Application Number: 2012-601 **Application Date:** 9/19/2012 12:00:00
CBL: 444-A-1 AM
Project Name: Casco Bay Ferry Terminal Improvements
Address: 56 Commercial Street

Project Name: Casco Bay Island Transit District
Address: 56 Commercial Street
Applicant: Casco Bay Island Transit District
Planner: Nell Donaldson

On June 5, 2013, the Planning Authority approved with conditions your Level II site plan for the improvements proposed at the Casco Bay Ferry Terminal at 56 Commercial Street. The decision is based upon the plan as submitted by Woodard & Curran (revisions dated May 7, 2013). The proposal was reviewed for conformance with the standards of the City of Portland's site plan ordinance (Section 14-526). The Level II site plan is approved with the following waivers and conditions:

56 Commercial Street - 444-A-001
#2012-601 - Easter Waterfront Port Zone (EWPZ)
11/19/2012

AREA REVISED
BY LOMR DATED
SEPTEMBER 27, 2011

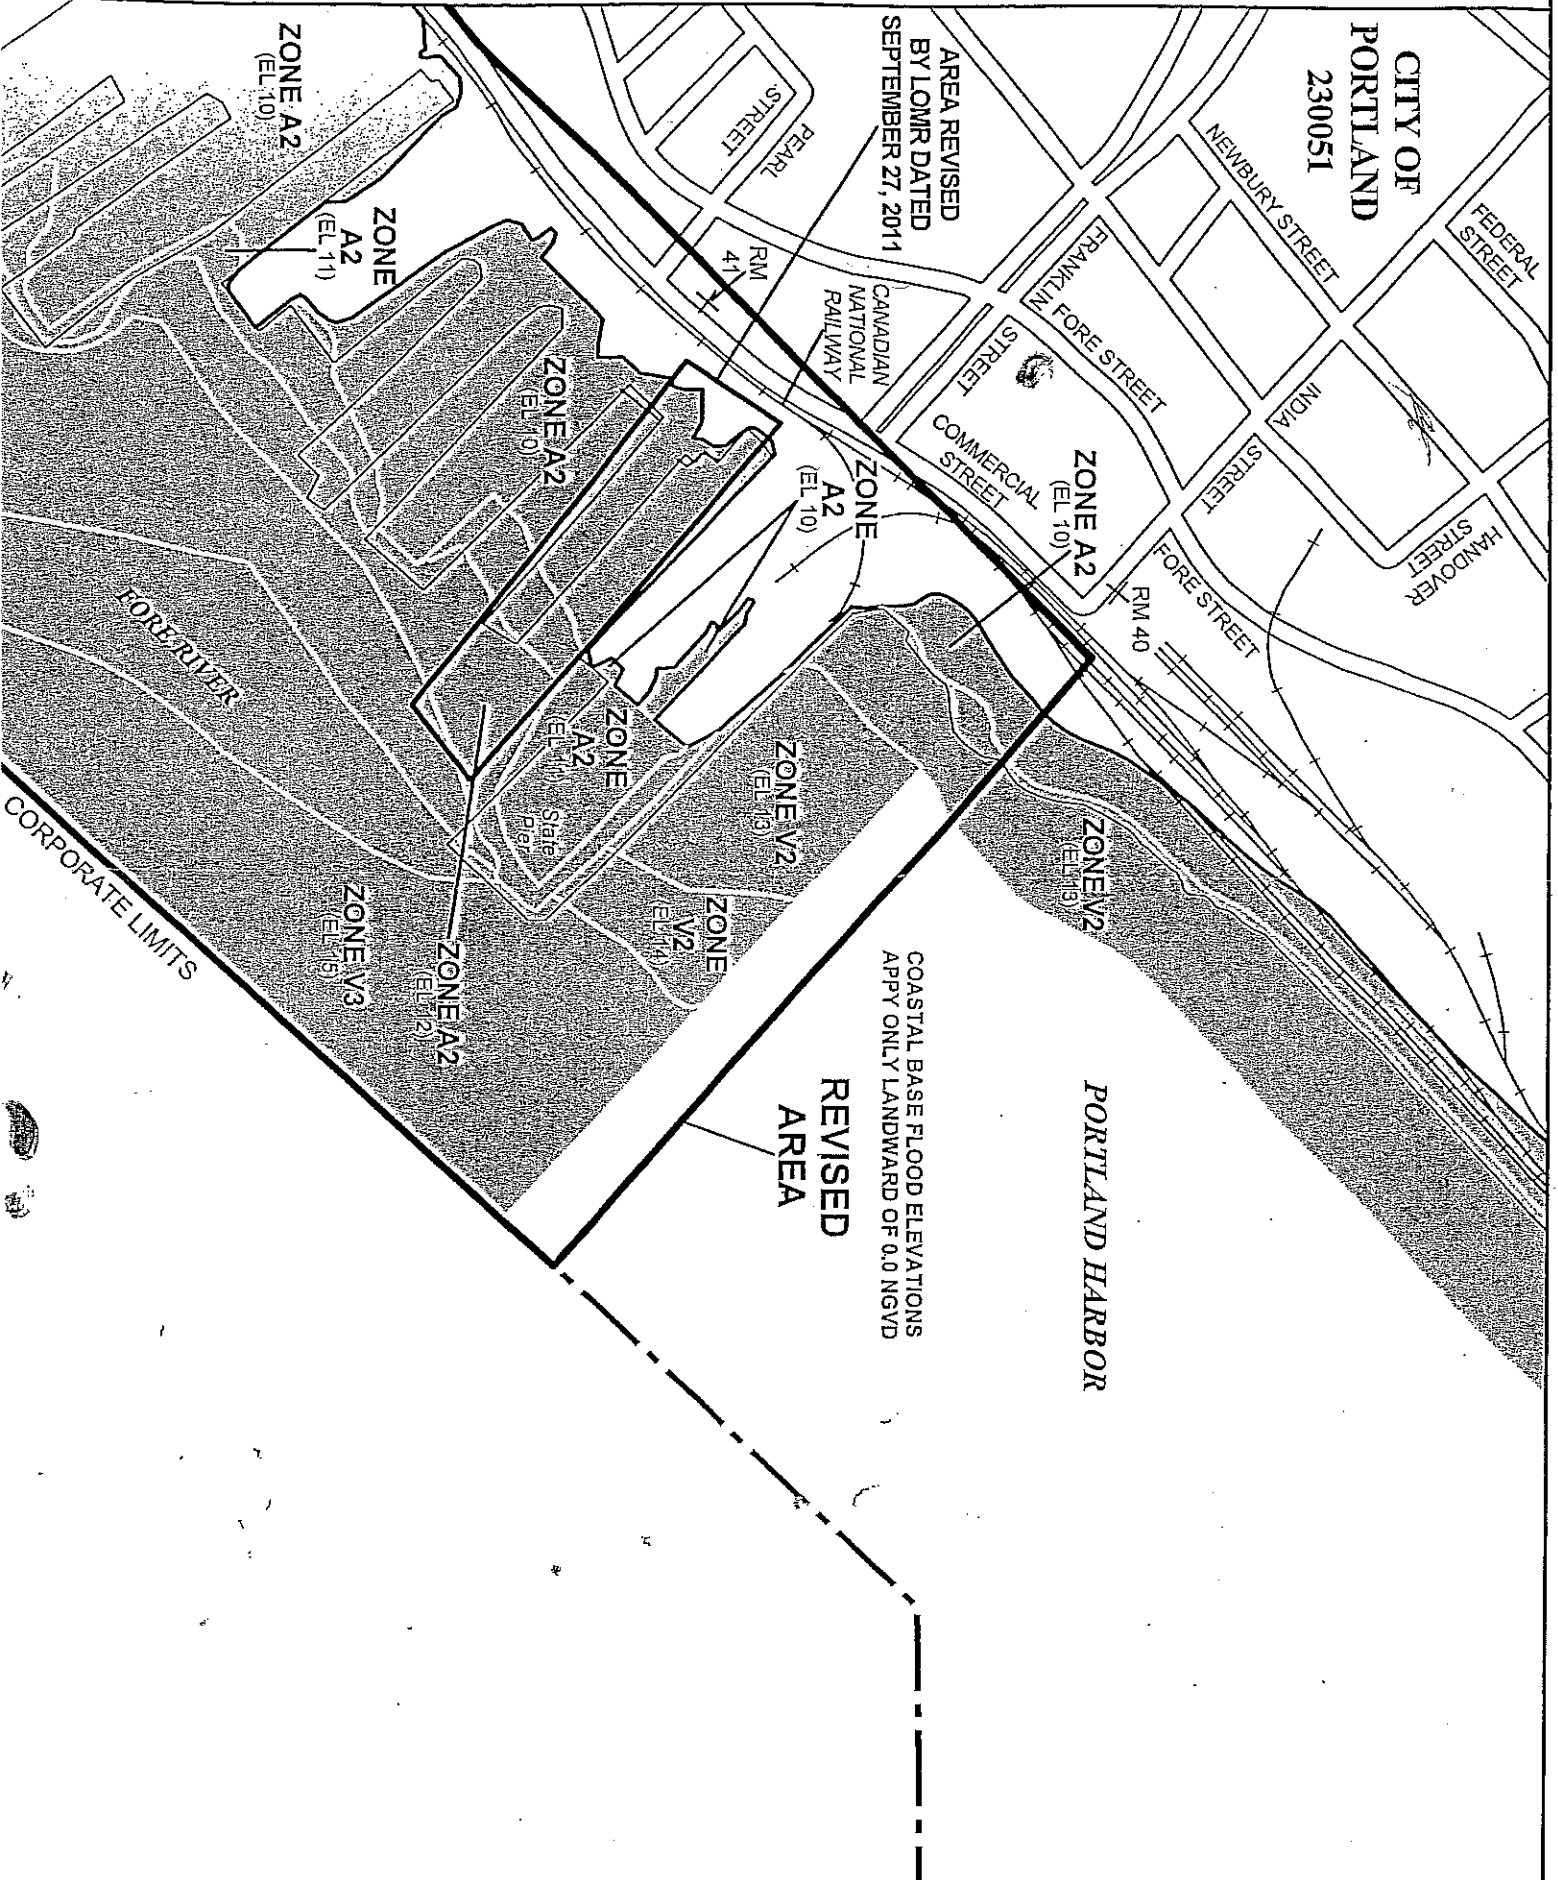
The project will still need to supply an Elevation Certificate in compliance with Floodplain regulations at the time of permit application. They must verify that the first floor elevation is at least 2 feet above the elevation of 9.6 NGVD as listed in the Flood Insurance Study promulgated by the Federal Emergency Management Agency for the City of Portland, or a minimum of 11.6 NGVD.

The project is also located in an A-2 Flood Zone with an elevation of 10 feet as shown on FEMA panel 14. Under the City of Portland requirements, the minimum floor area for the addition shall be no less than 2 feet above the given map elevation of 10., or at least 12'. The applicant is showing 12.33 feet. The applicant will be required to fill out the paper work and a certificate of elevation for the new addition when appropriate.
